CITY OF PORTLAND, MAINE

August 14, 2015

Project Name: **Subdivision of the McAuley site & conversion of the Motherhouse for senior housing**
Project ID: #2015-110
Address: 605 Stevens Avenue CBL: 136 E006001
Applicant: Motherhouse Associates, LP & Sea Coast at Baxter Woods Associates, LLC
Planner: Jean Fraser

TO: Jean Fraser, Planner
FROM: David Senus, P.E.
DATE: August 5, 2015
RE: Motherhouse Senior Housing, Final Level III Site Plan Application

Sheet No:
C4.0

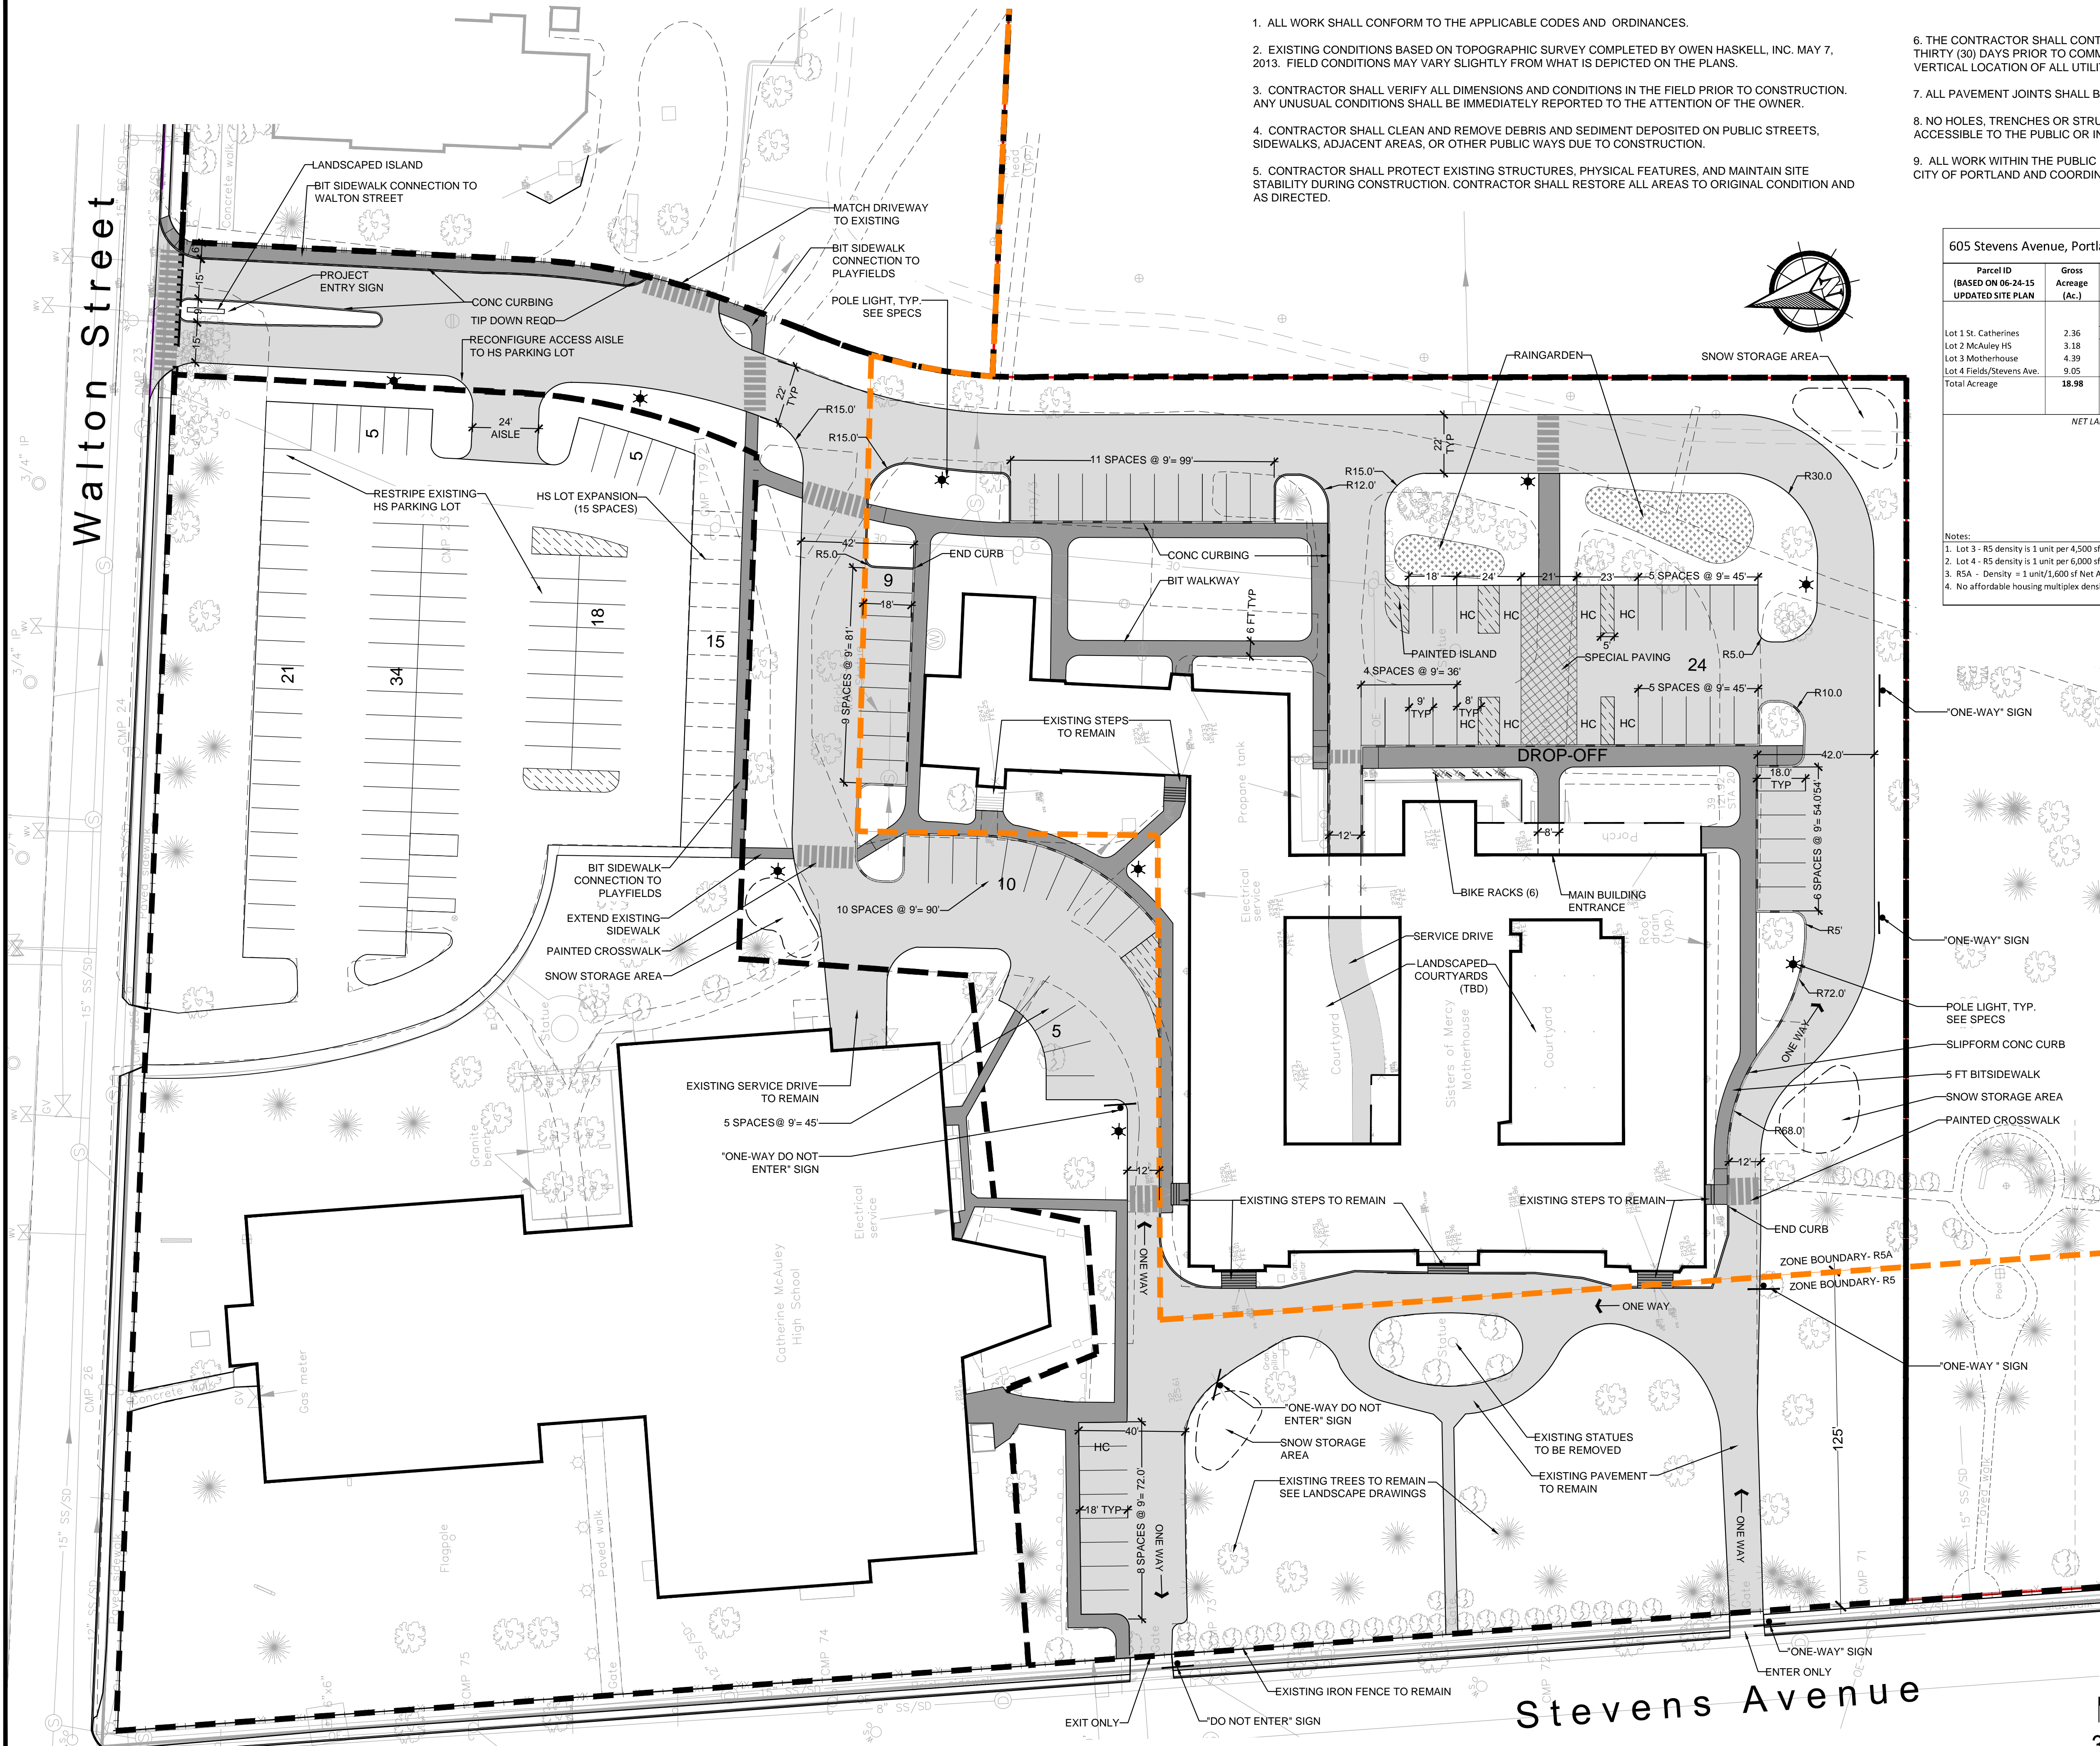
* The aisle width (22 feet) adjacent to the 8 parking spaces on the one-way egress road near Stevens Avenue does not meet City standards. Information in support of a formal technical standard waiver request shall be provided.

* The applicant should provide dimensional details for the area on the north side of the building where the 5 and 10 space parking areas are located.

* The applicant should review landscaping and other features as it relates to providing safe sight distance when existing the site onto Stevens Avenue. I am particularly concerned about safety for pedestrians on the sidewalk.

* A detail should be provided for the sidewalk ramp at the driveway on Walton Street to ensure that it is fully accessible.

Final Status: The sidewalk ramp detailed on the plan is not acceptable. The alignment of the ramp shall direct pedestrians along the Walton Street sidewalk. The applicant shall submit a revised plan for review and approval.

- vi. That the applicant shall address the comments of the Traffic Engineering Reviewer dated 8.6.2015 regarding the sight lines to pedestrians for the exit drive on Stevens Avenue, and the ramp design at the Walton Street driveway, both prior to the issuance of a building permit; and

DRAWN: DED DATE: JUNE 2015
DESIGNED: ADJ SCALE: 1" = 40'
CHECKED: ADJ JOB NO. SP-M162
FILE NAME: SP-M162 GRADING
SHEET: C6.0

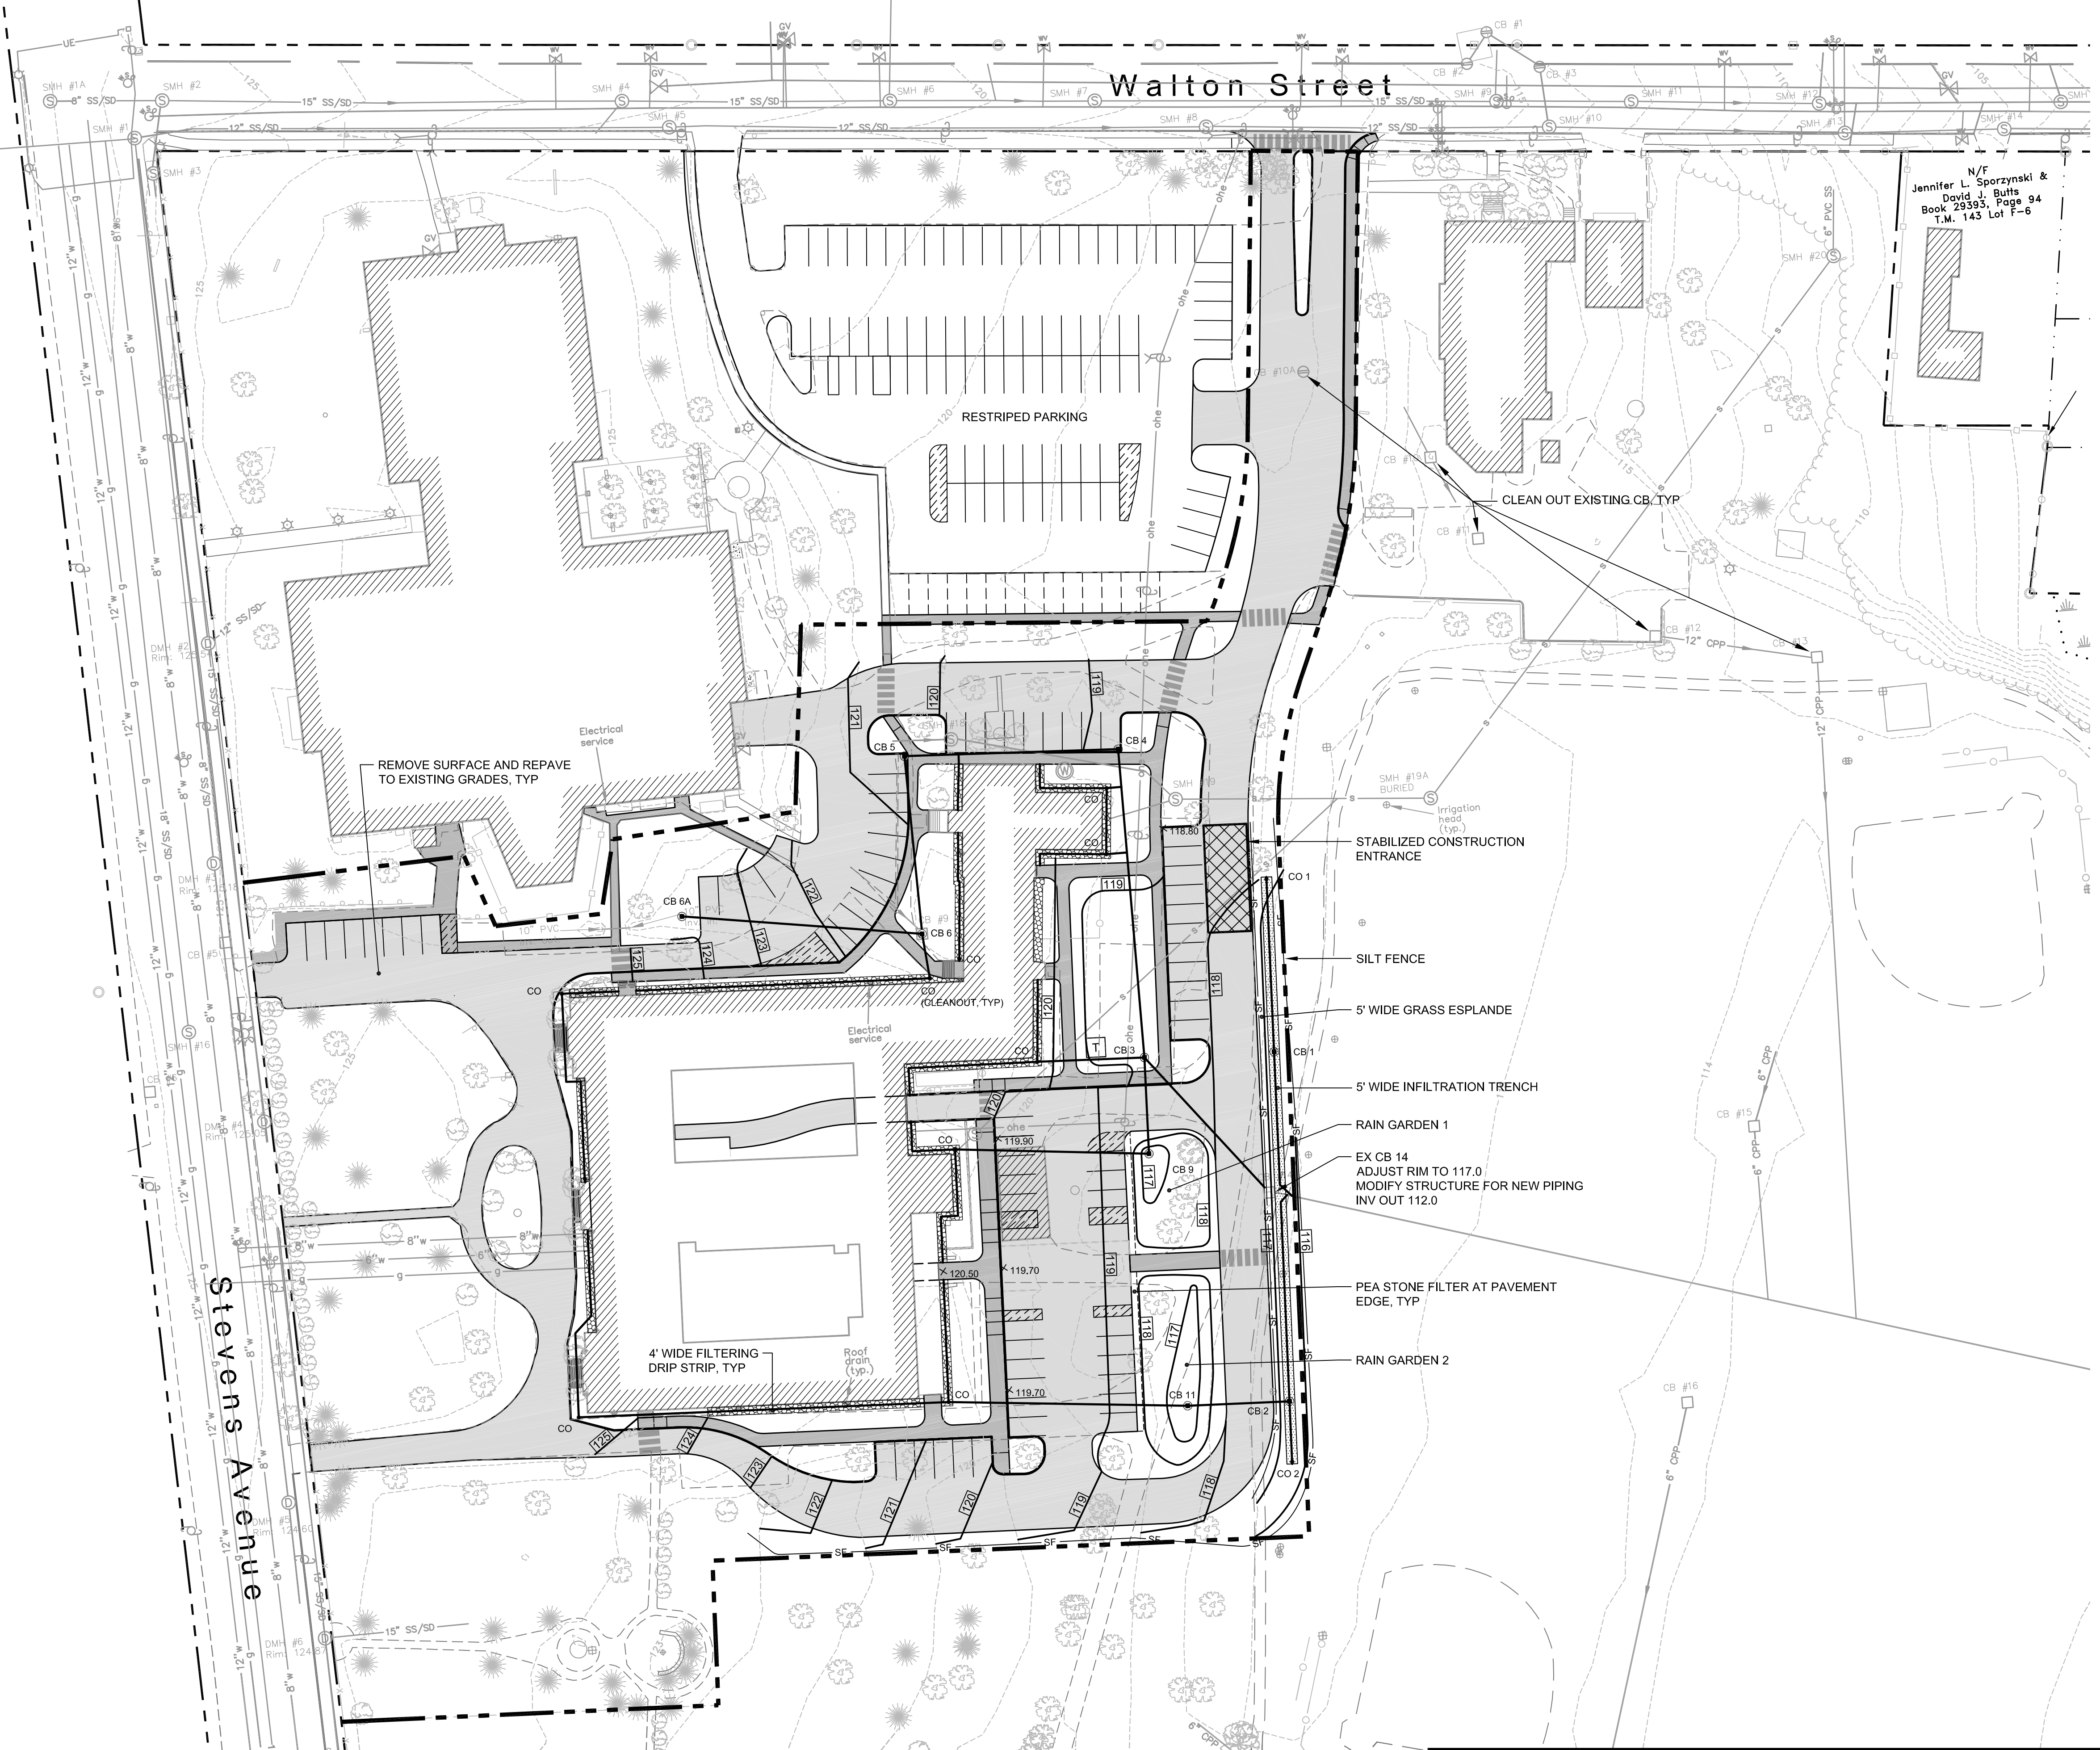
- 1) A Plan, notes, and details have been provided to address erosion and sediment control requirements, inspection and maintenance requirements, and good housekeeping practices in general accordance with Appendix A, B, & C of MaineDEP Chapter 500; however, Sheet C6.0 should specify locations for catch basin inlet protection devices.

- 2) The proposed stormwater management system will rely on an existing 12" Corrugated Plastic Pipe installed below the ball fields to convey excess drainage away from the development area. The Applicant has noted that the outlet of the existing pipe has been inspected and appears to be in stable and good condition, and that the entire length of the pipe will be inspected with CCTV prior to construction to verify condition and suitability for reuse. Woodard & Curran recommends that this be made a condition of approval, to occur prior to receiving a building permit.

- iv. That the applicant shall address the comments of the Peer Engineering Reviewer dated 8.5.2015 regarding catchbasin information, and the further inspection of the existing 12" Corrugated Plastic Pipe installed below the ball fields to verify condition and suitability for reuse, both prior to the issuance of a building permit; and
